BEFORE THE KITTITAS COUNTY HEARING EXAMINER

In the matter of an appeal of the: Mitigated Determination of Non-significance for 3 BR Custom Cuts	CDS FILE NO. CU-23-0001 NOTICE OF APPEAL
---	---

Wilson Creek Neighbors, an unincorporated association of property owners, file this appeal of Kittitas County SEPA Responsible Officials *Mitigated Determination of Nonsignificance* issued February 7, 2024.

**3BR CUSTOM CUTS  
PROCESSING PLANT**

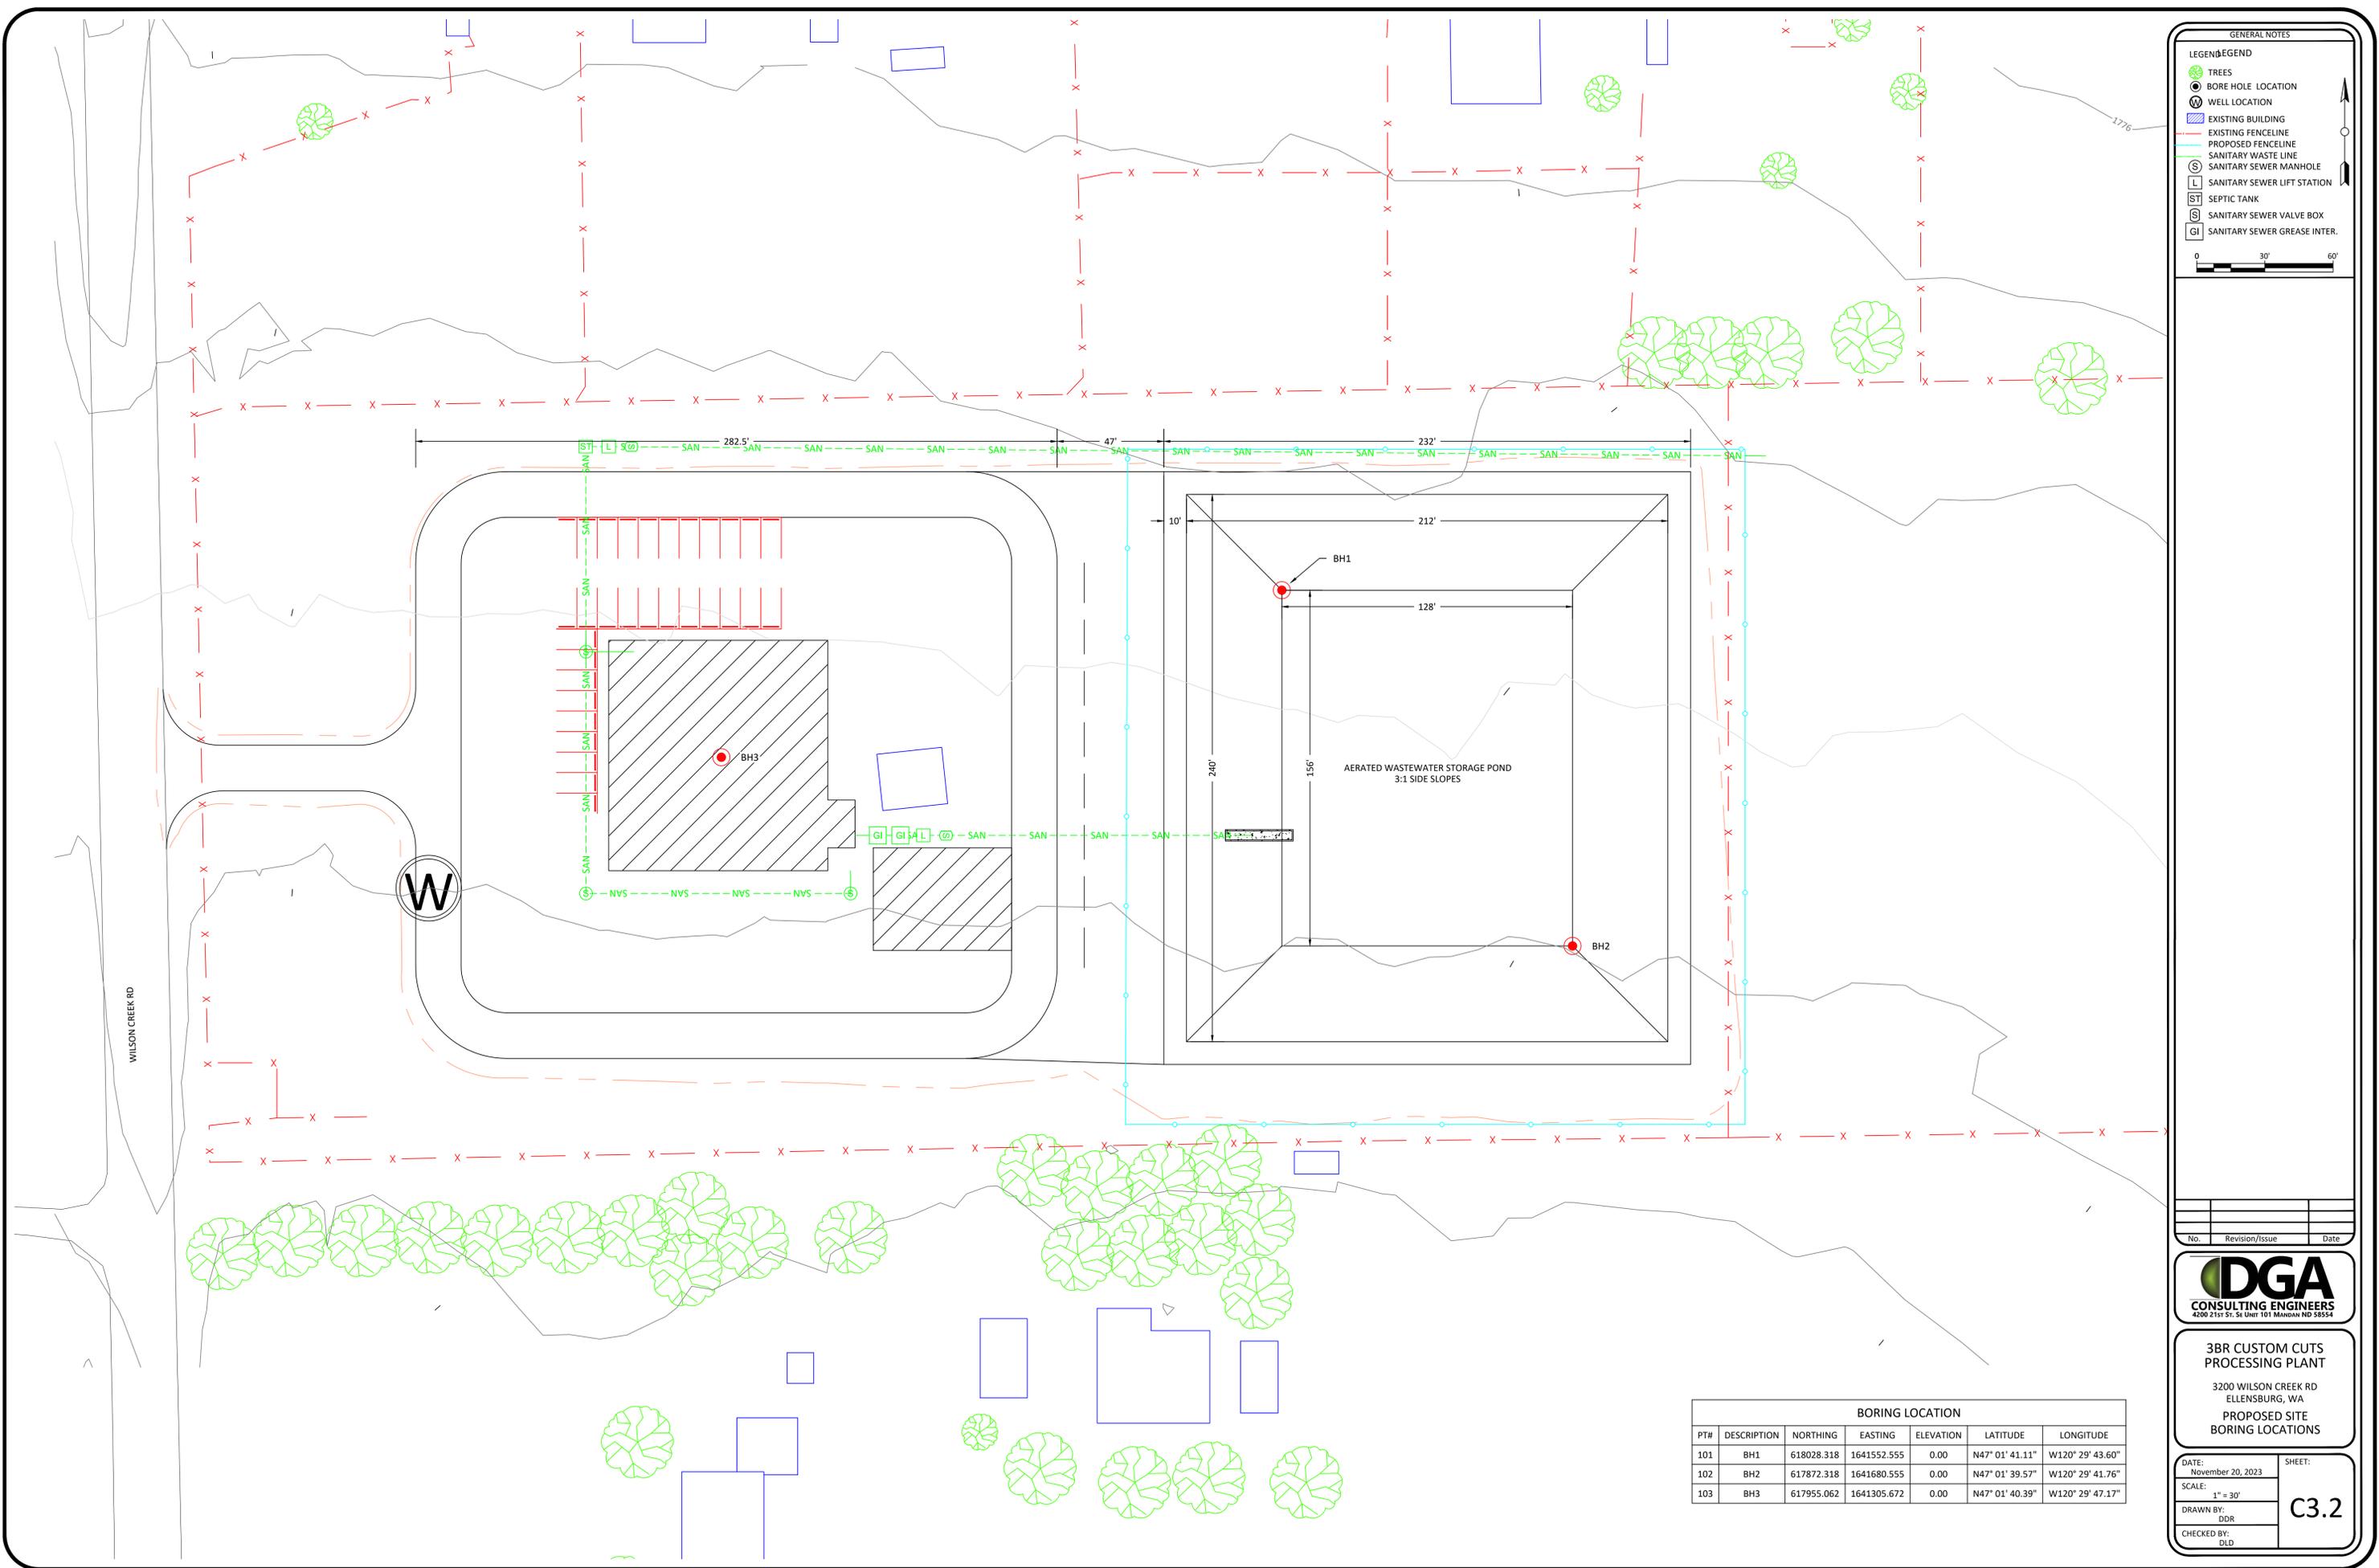
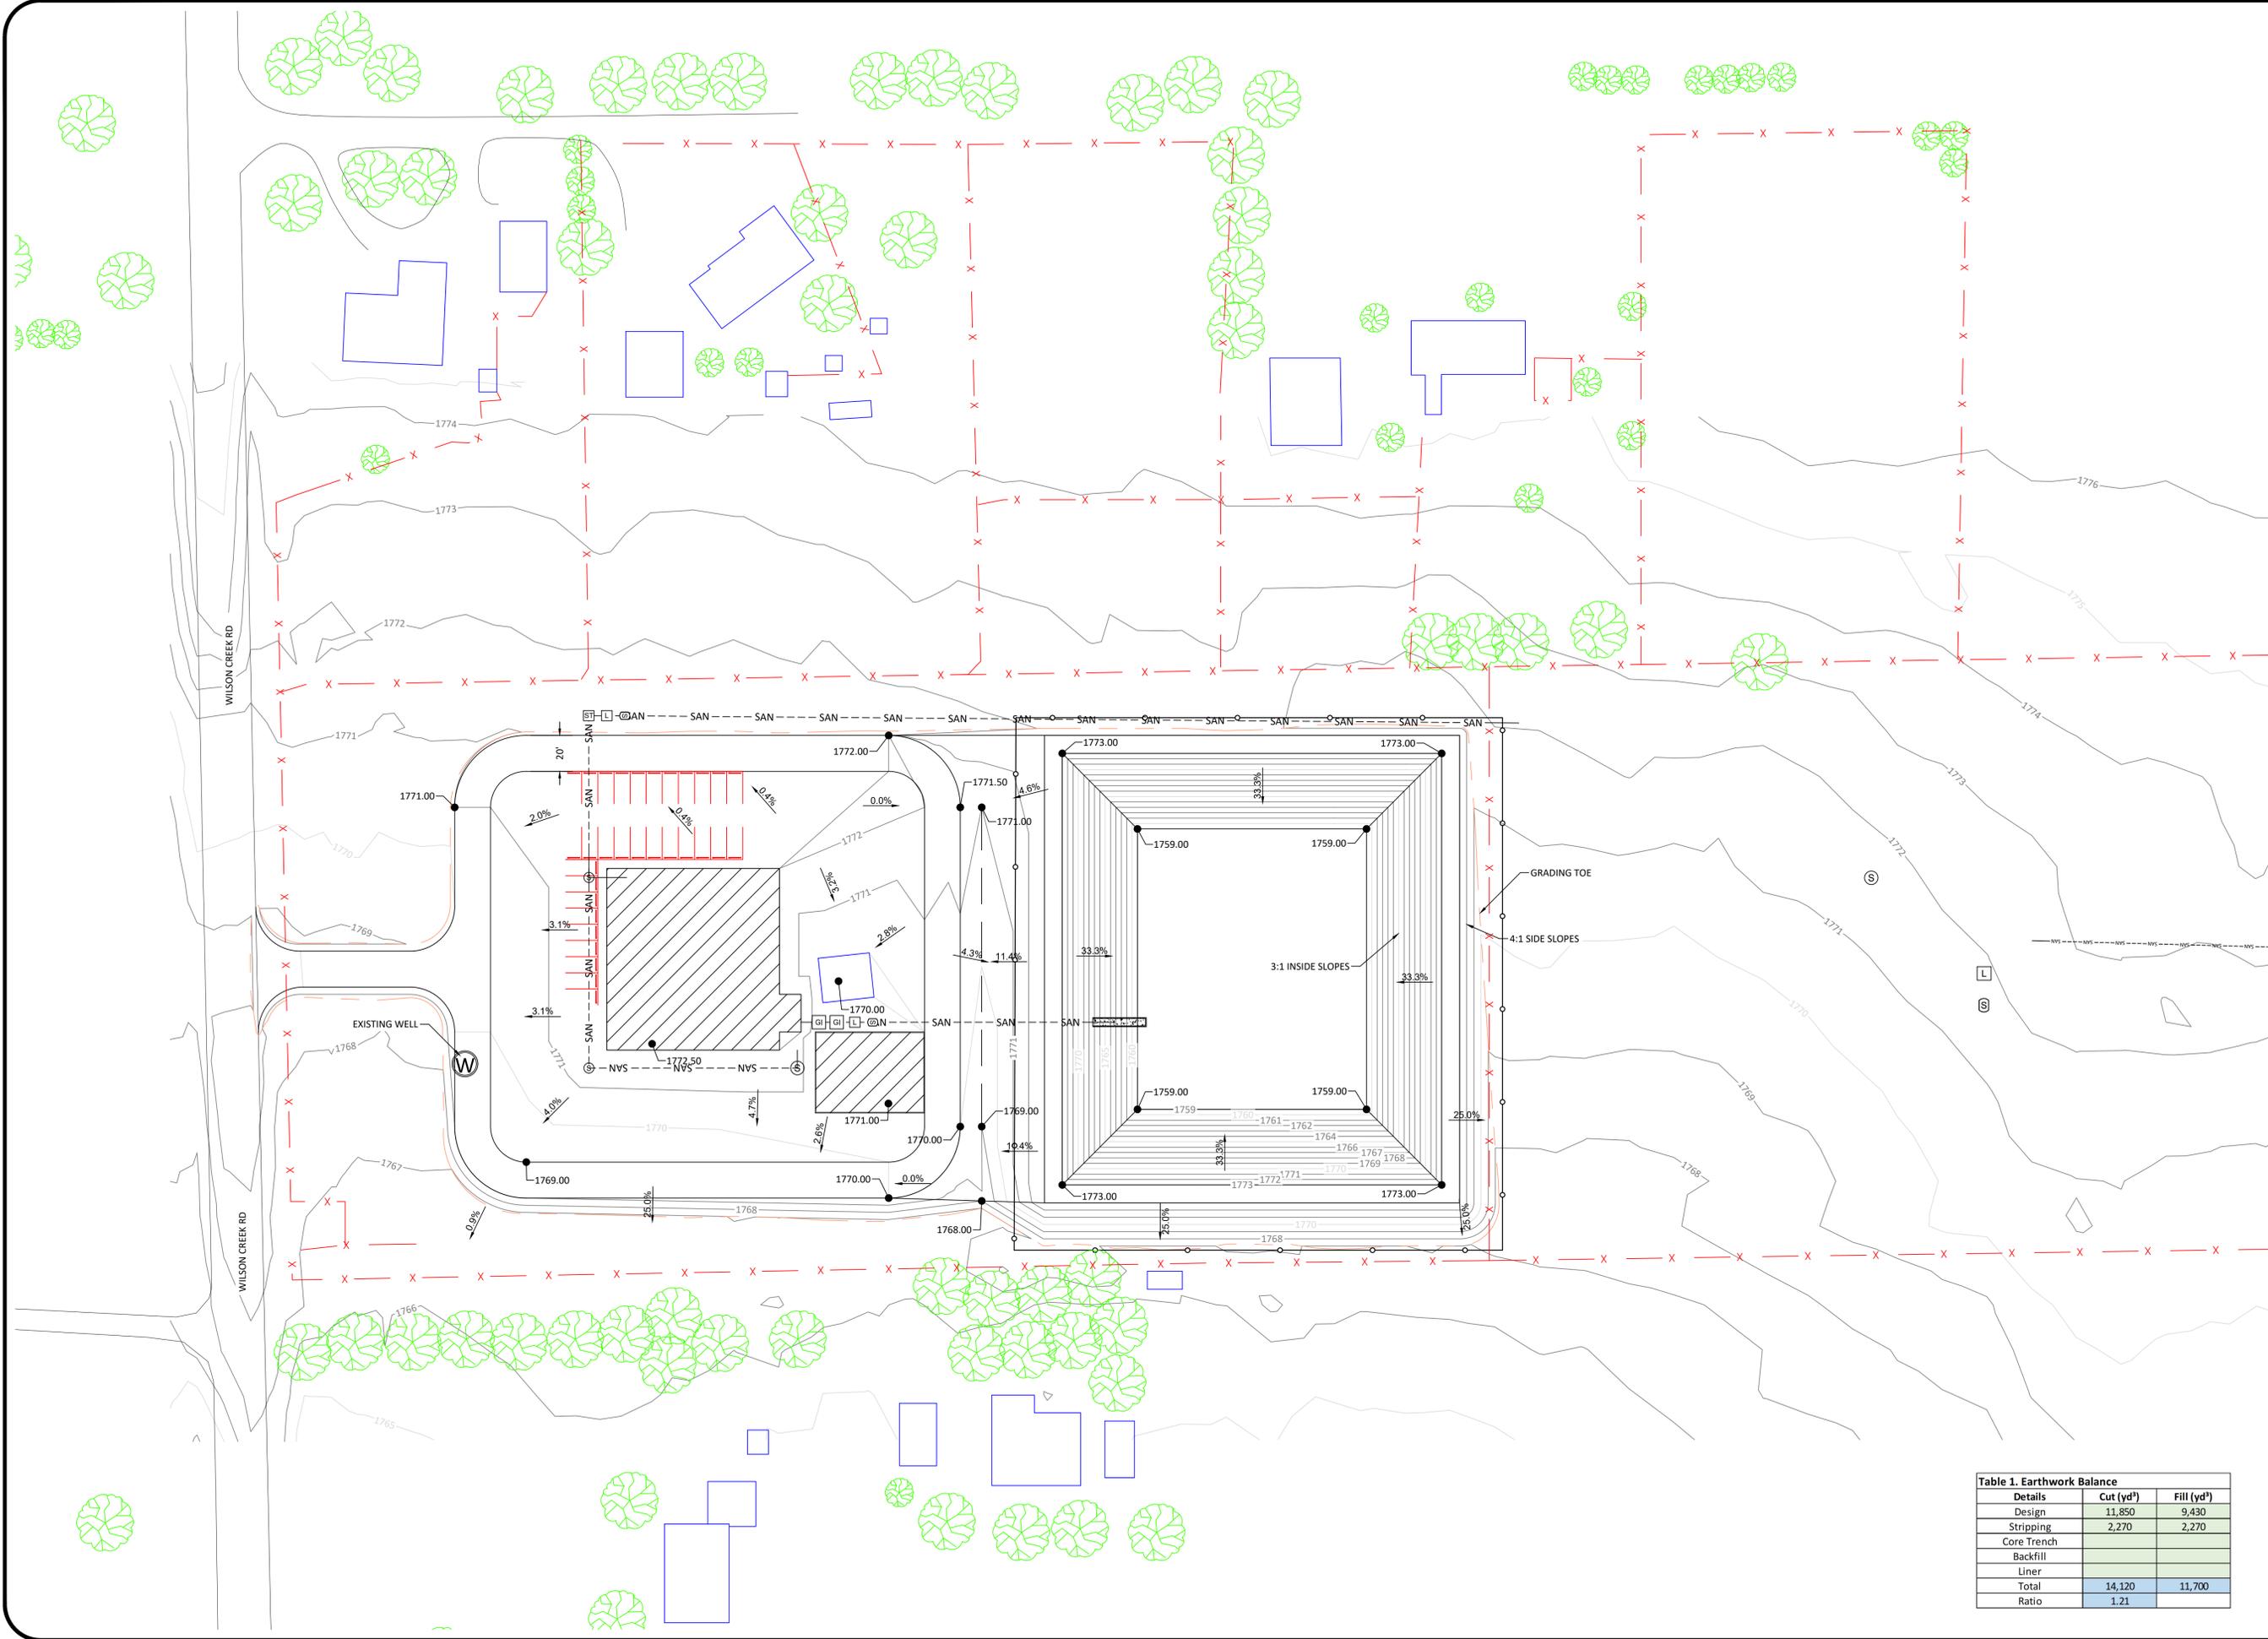
29 SEPA checklist Section 3(e) states that there will be “...limited excavation to
30 install the proposed aerated treatment pond.” Site plans suggest that total cut and fill would be

1 approximately 25,820 cubic yards. The excavation contemplates a wastewater treatment pond
2 that is fourteen feet (14') deep with extensive perimeter berms. SEPA Responsible Official failed
3 to identify, evaluate or consider the excavations. KCC 14.05.080 requires an engineered grading
4 plan for any excavation in excess of 500 cubic yards. SEPA Checklist is incomplete and
5 inadequate in describing and providing information with regard to soils, cuts, fills, and
6 development plans. All environmental impacts are to be evaluated at the earliest possible stage.
